From: Biazar, Shahab
Sent: Friday, November 08, 2013 8:48 AM
To: 'Trula Howe'
Subject: RE: Confirm

SANTA FE FEDERAL CREDIT UNION
GRADING AND DRAINAGE PLAN
ALBUQUERQUE, NEW MEXICO

July 3, 2013

Re: Santa Fe Federal Credit Union, 7101 Jefferson Street NE, Grading and Drainage Plan, Engineer's Stamp dated 06-04-2013 (D-17/D017)

SHEET NUMBER
C.1

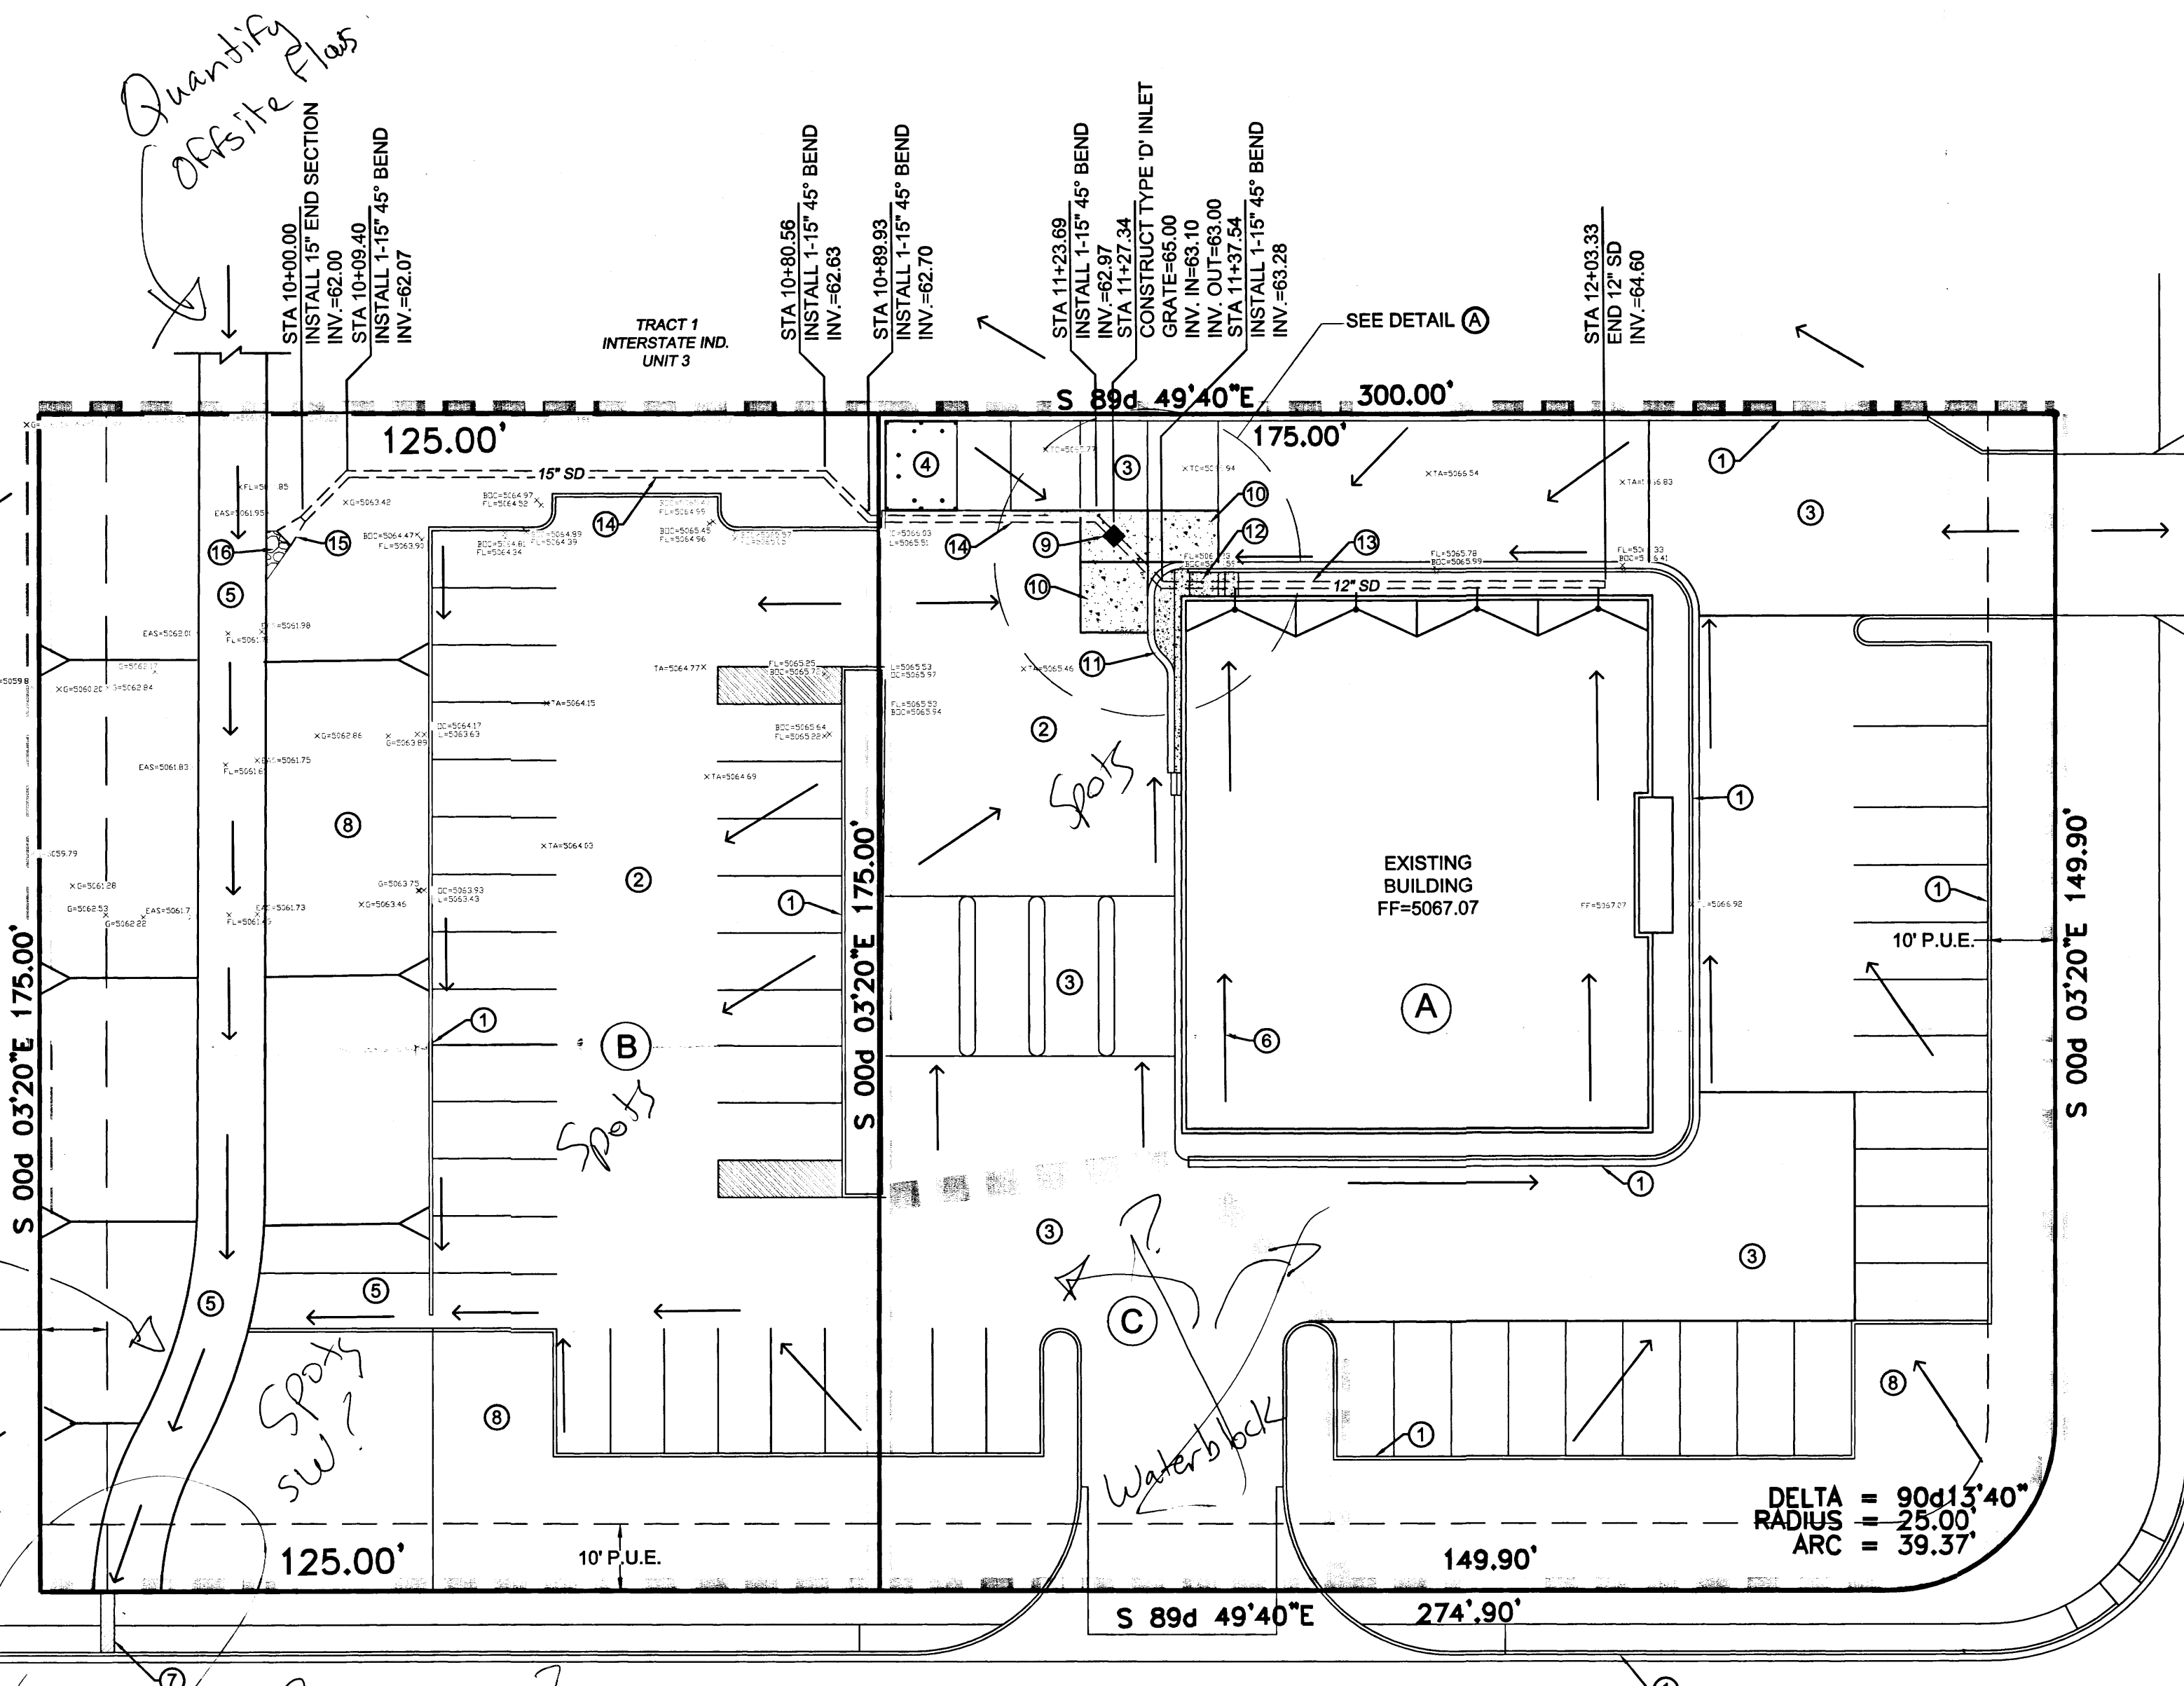
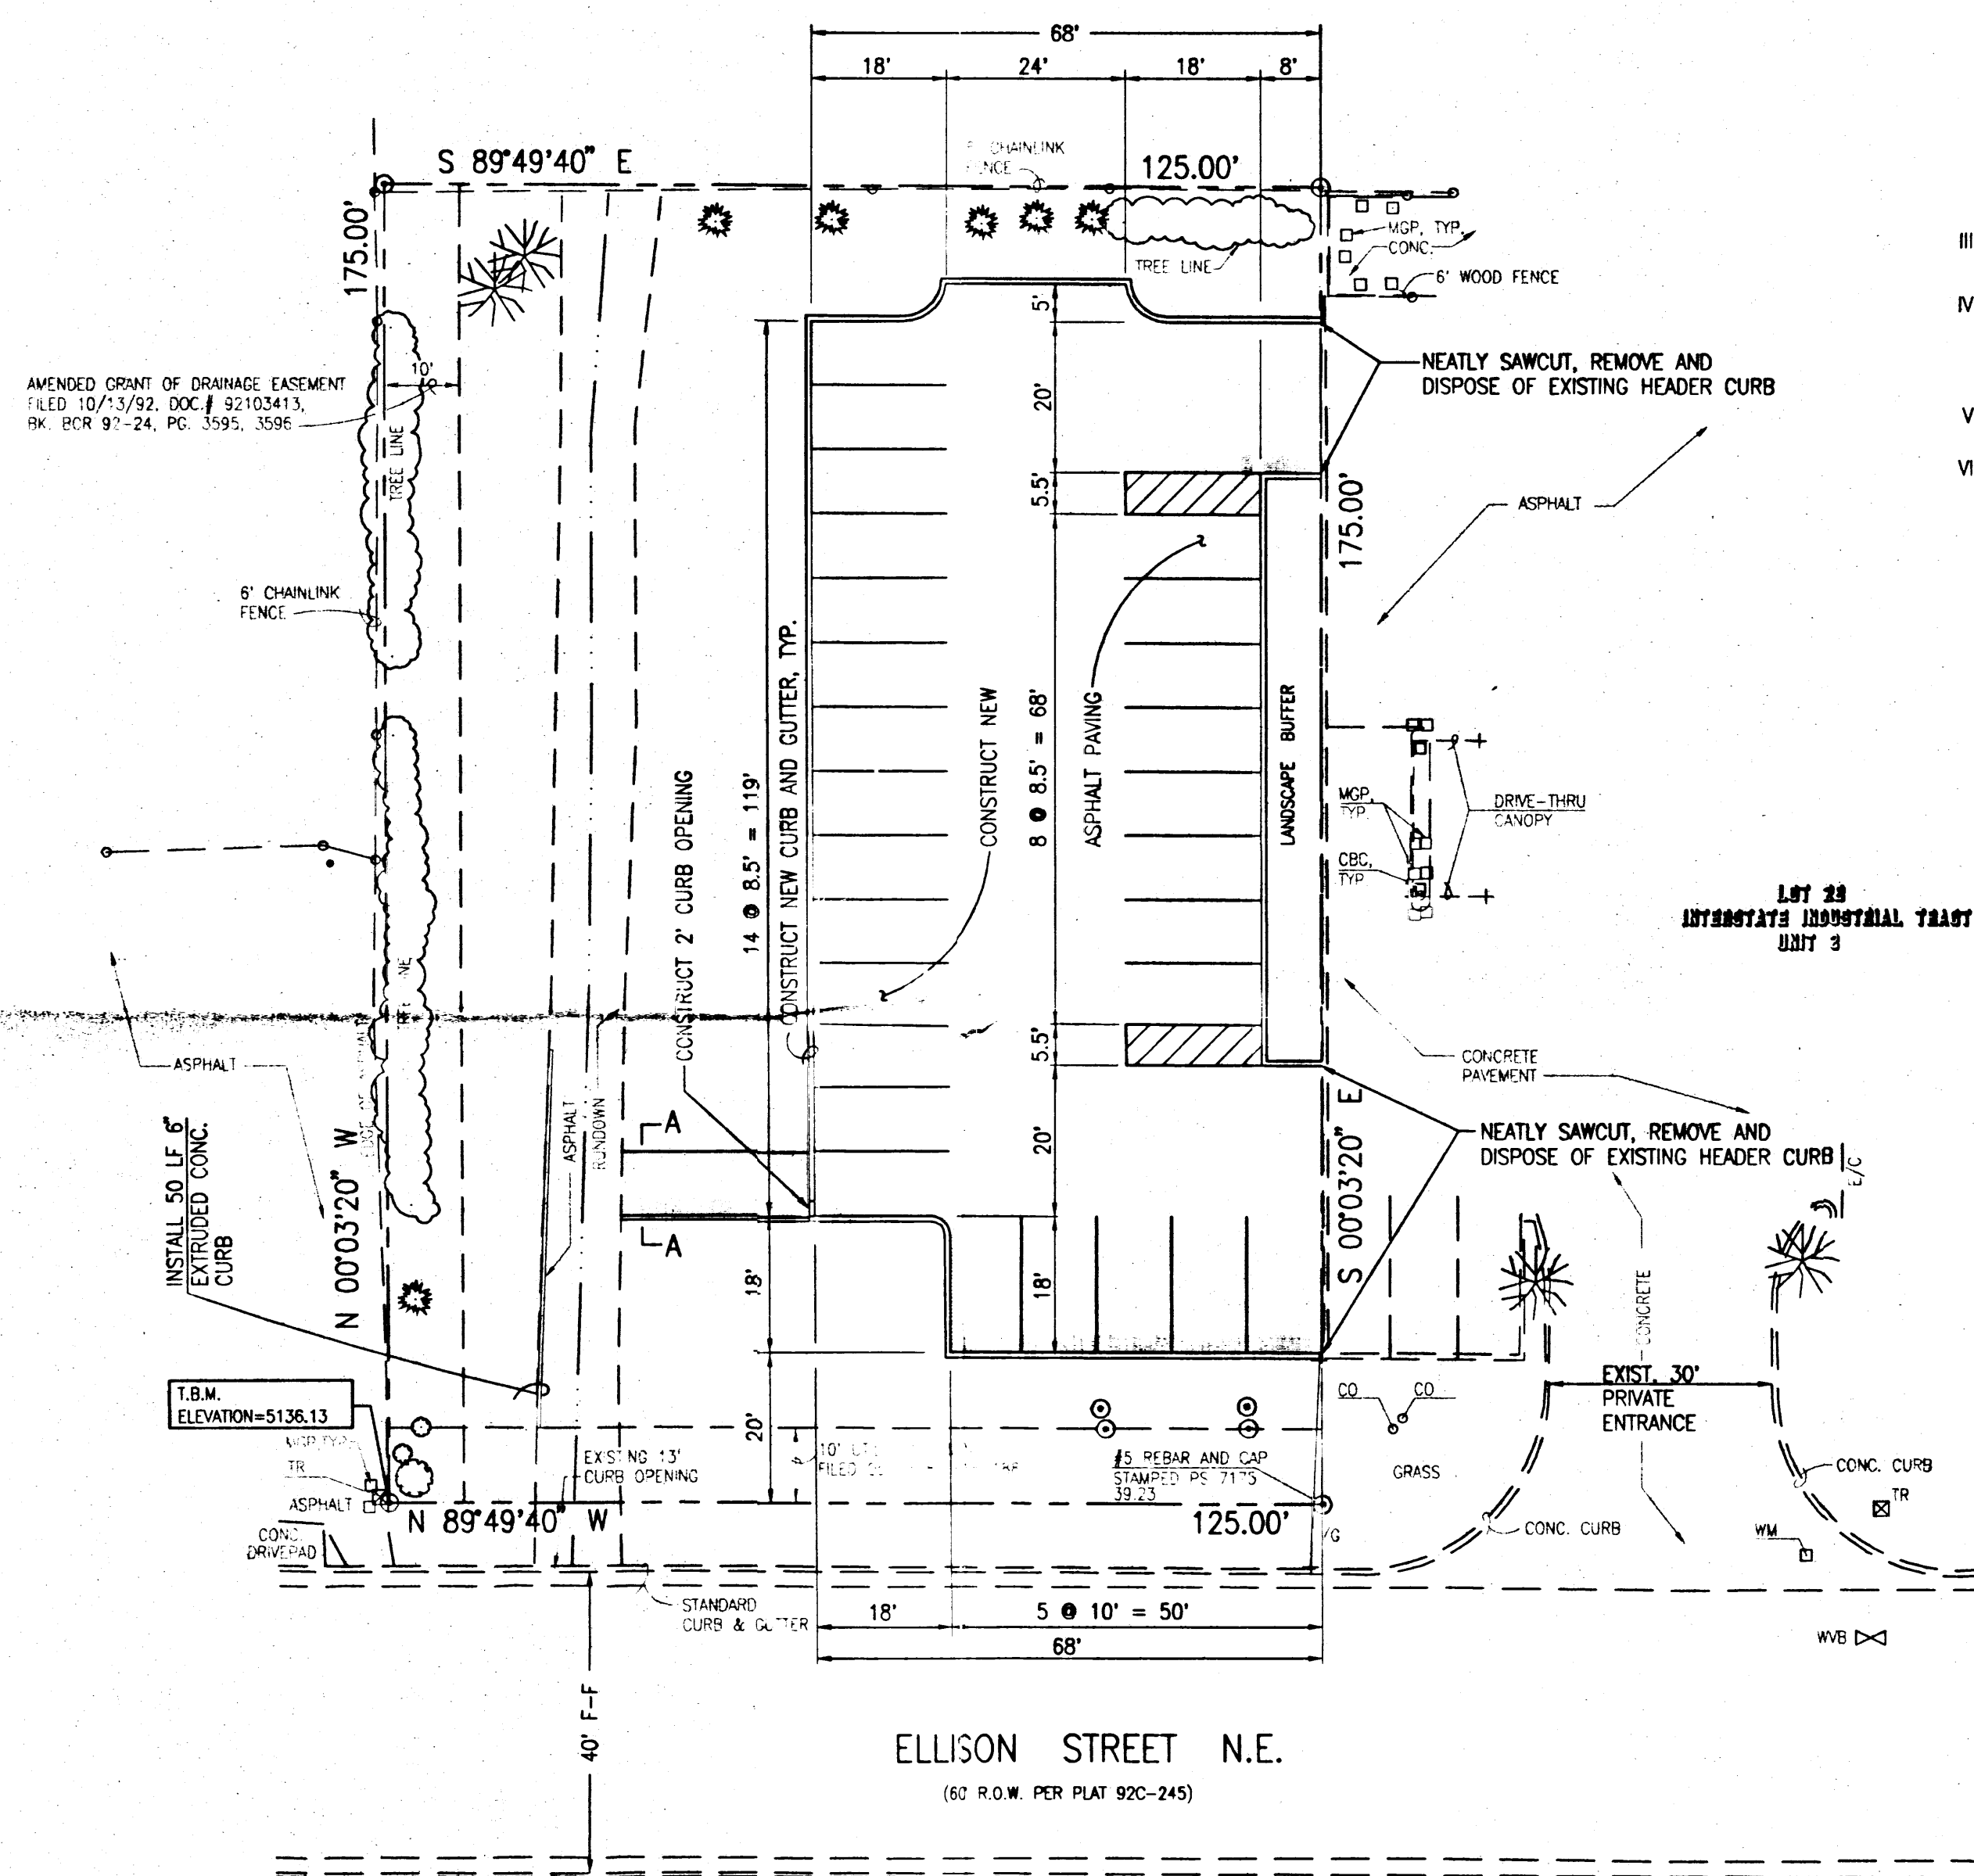
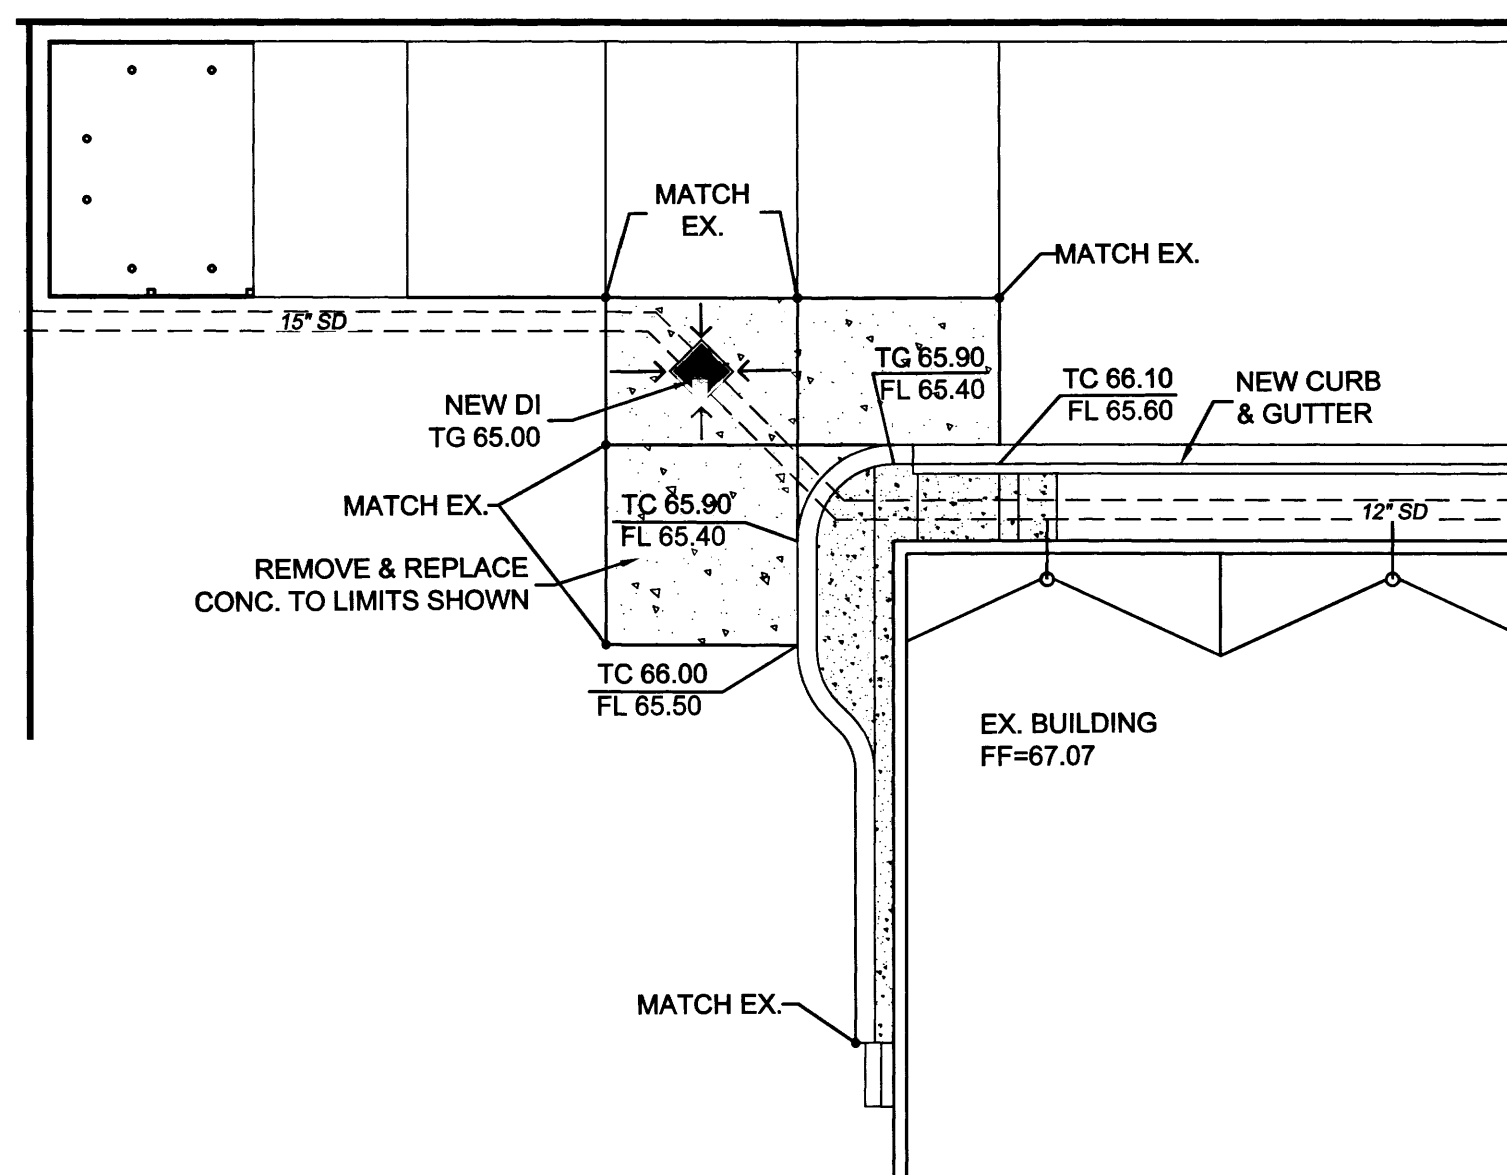
- Please quantify the offsite flows from the parking lot to the north of your project and include these flows in the drainage calculations for the existing sidewalk culvert; if over capacity address how these flows will be accommodated.
- Add a note to extend the culvert and culvert plate two feet back from the property line and to tack weld the bolts to the steel plate.
- Clarify if the existing swale is completely asphalt lined. Satellite imagery shows a significant amount of sediment in this channel.
- If the sidewalk culvert is altered please provide both an invert elevation and flowline elevations within Ellison Street.
